MEMORANDUM

Project No.: 17077
Project Name: TPI Harris Containers

To: Review team
From: Keith Ewing, PE
Date: July 31, 2018
Re: 93 Washington Ave. – Follow up 2
Cc:

Sheet
S1.1

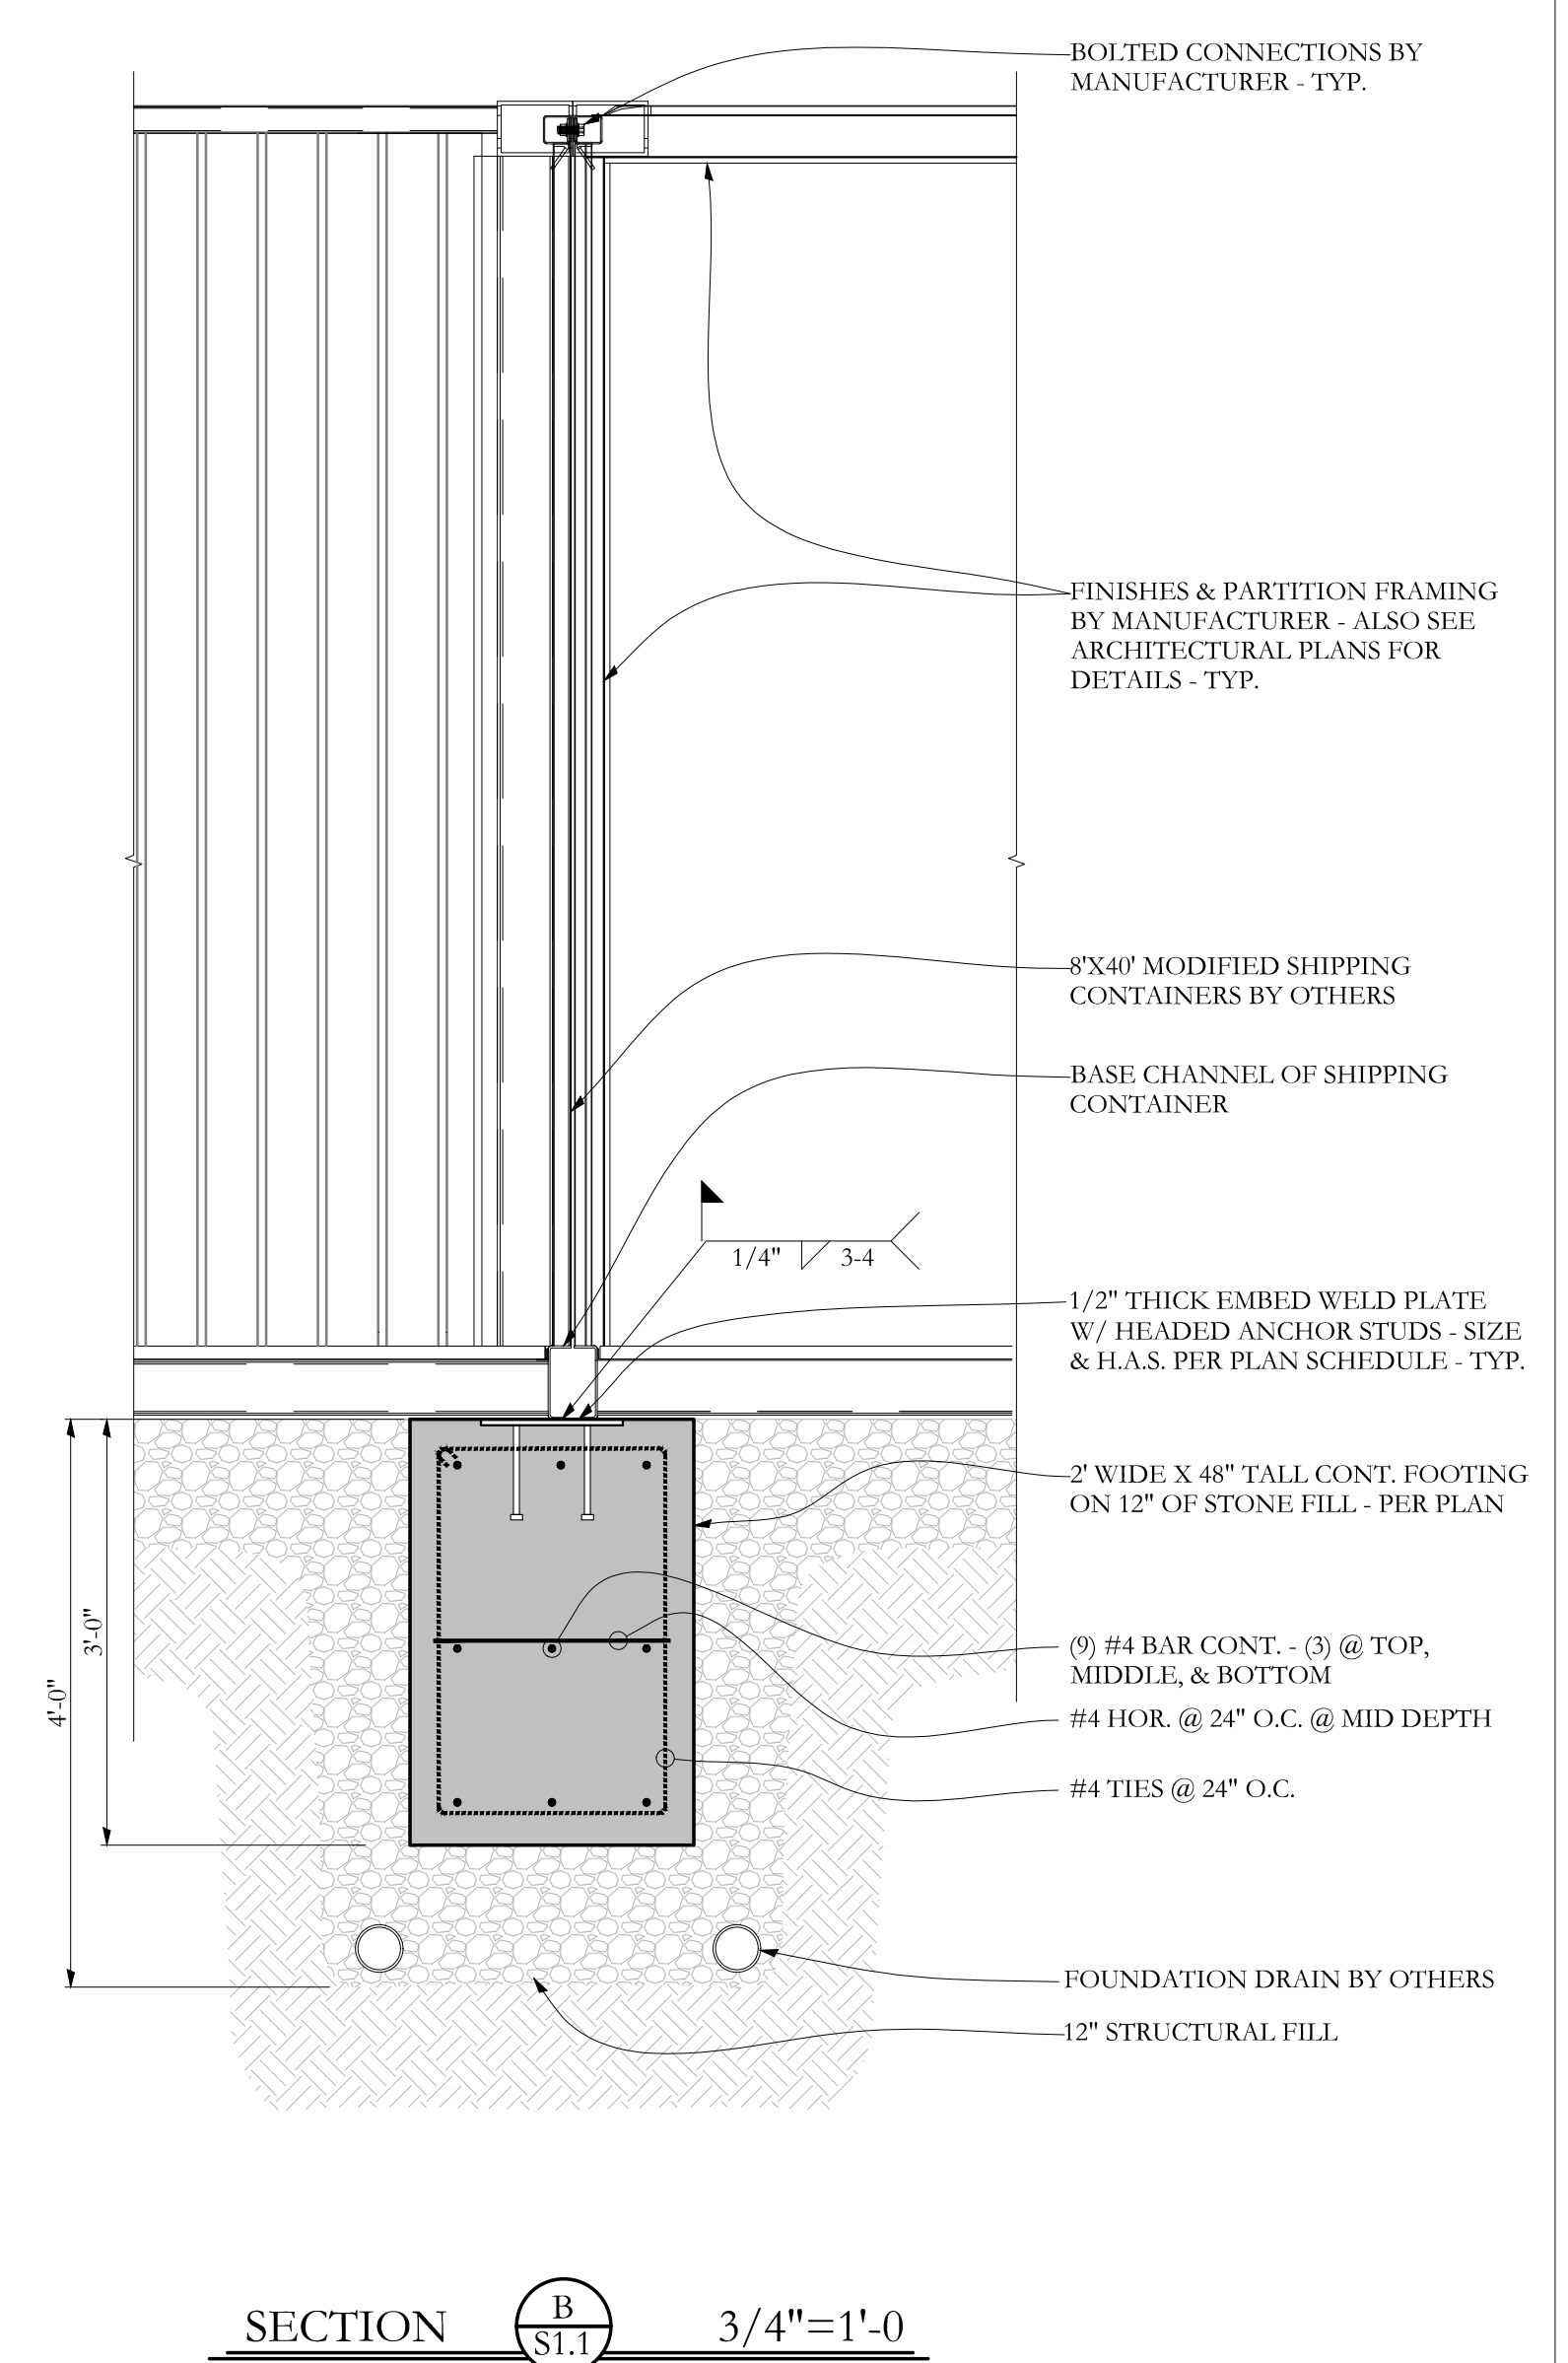
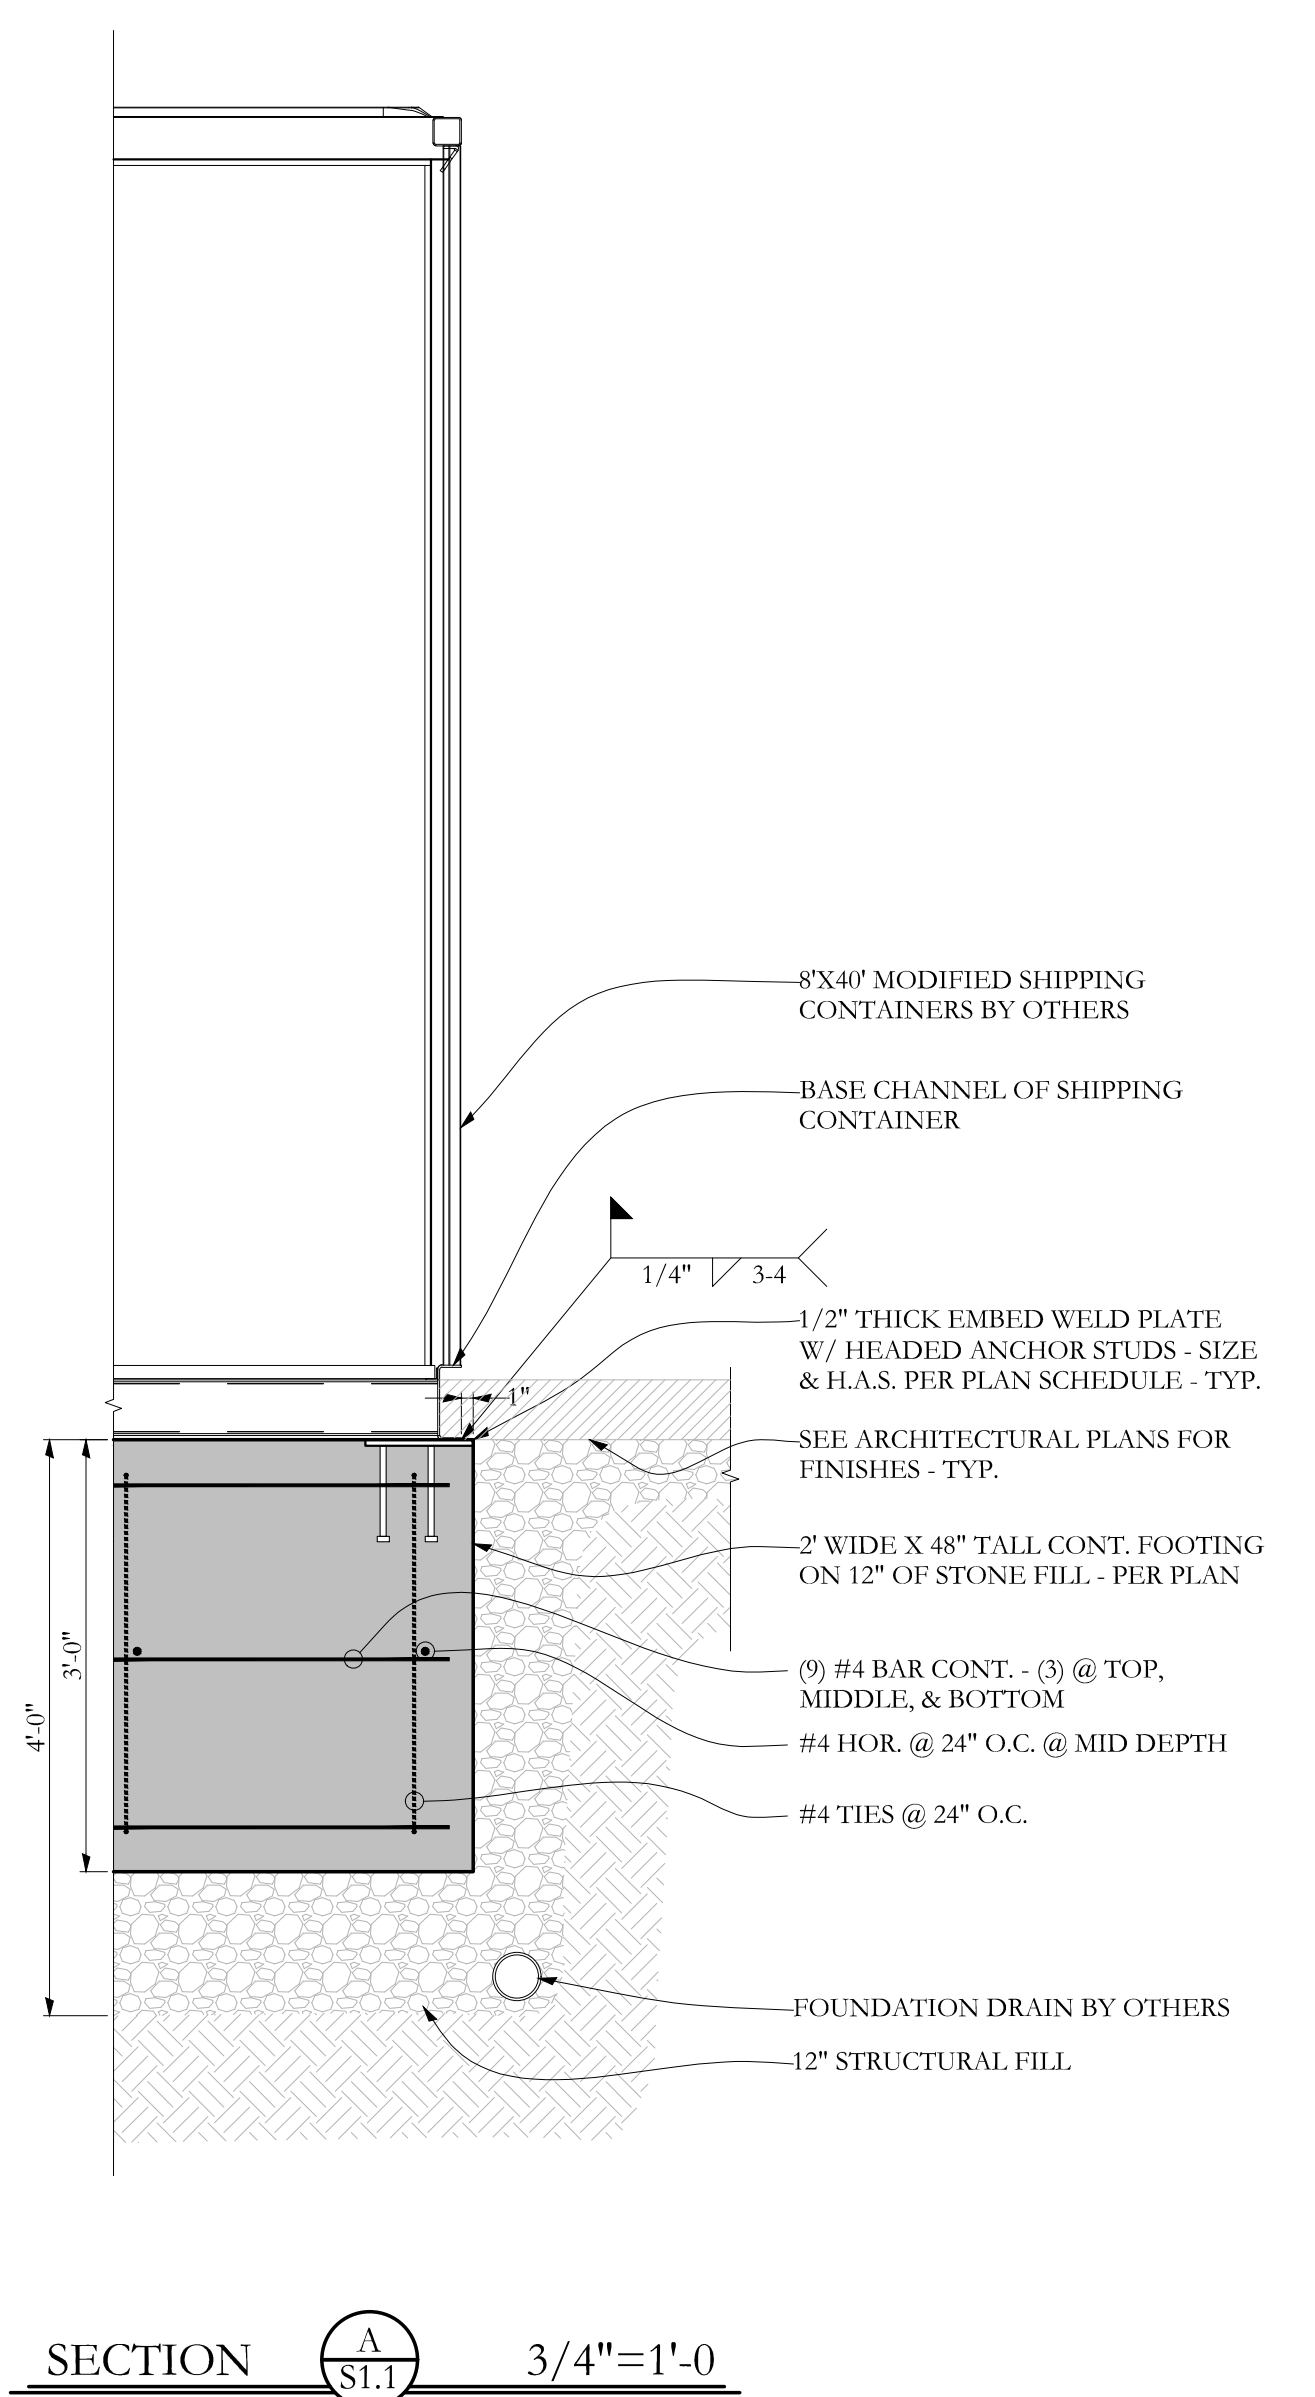
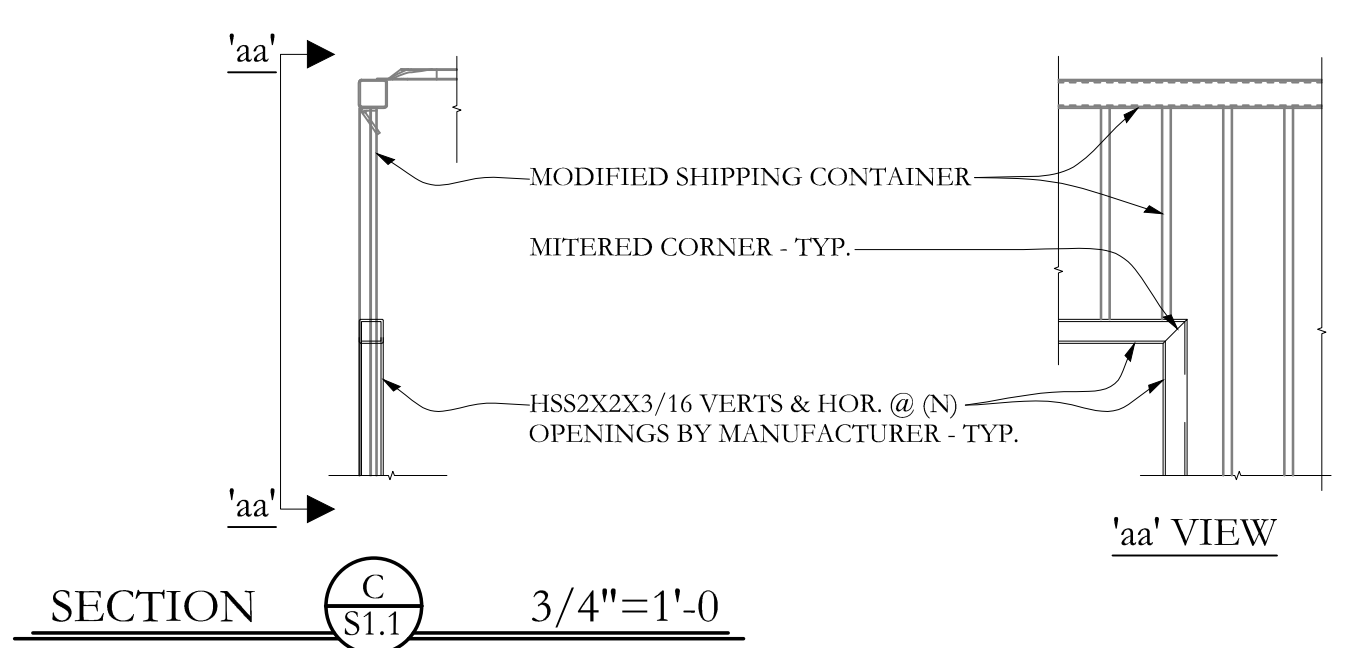
2. The letter from Keith dated 5/1/17 was preliminary to the development of the PID shipping container policy. My reply at the time, upon receipt from Jed Harris and Abigail Couture, was that the list of plans reviewed by Keith did not reference the structural, S-Plans. Please address this and follow up.

- a) *The structural drawings "S1 and S2" were kept in a separate pdf file so they were not included in the list. They were reviewed prior to the structural modification to the containers, as noted in the special inspection report.*
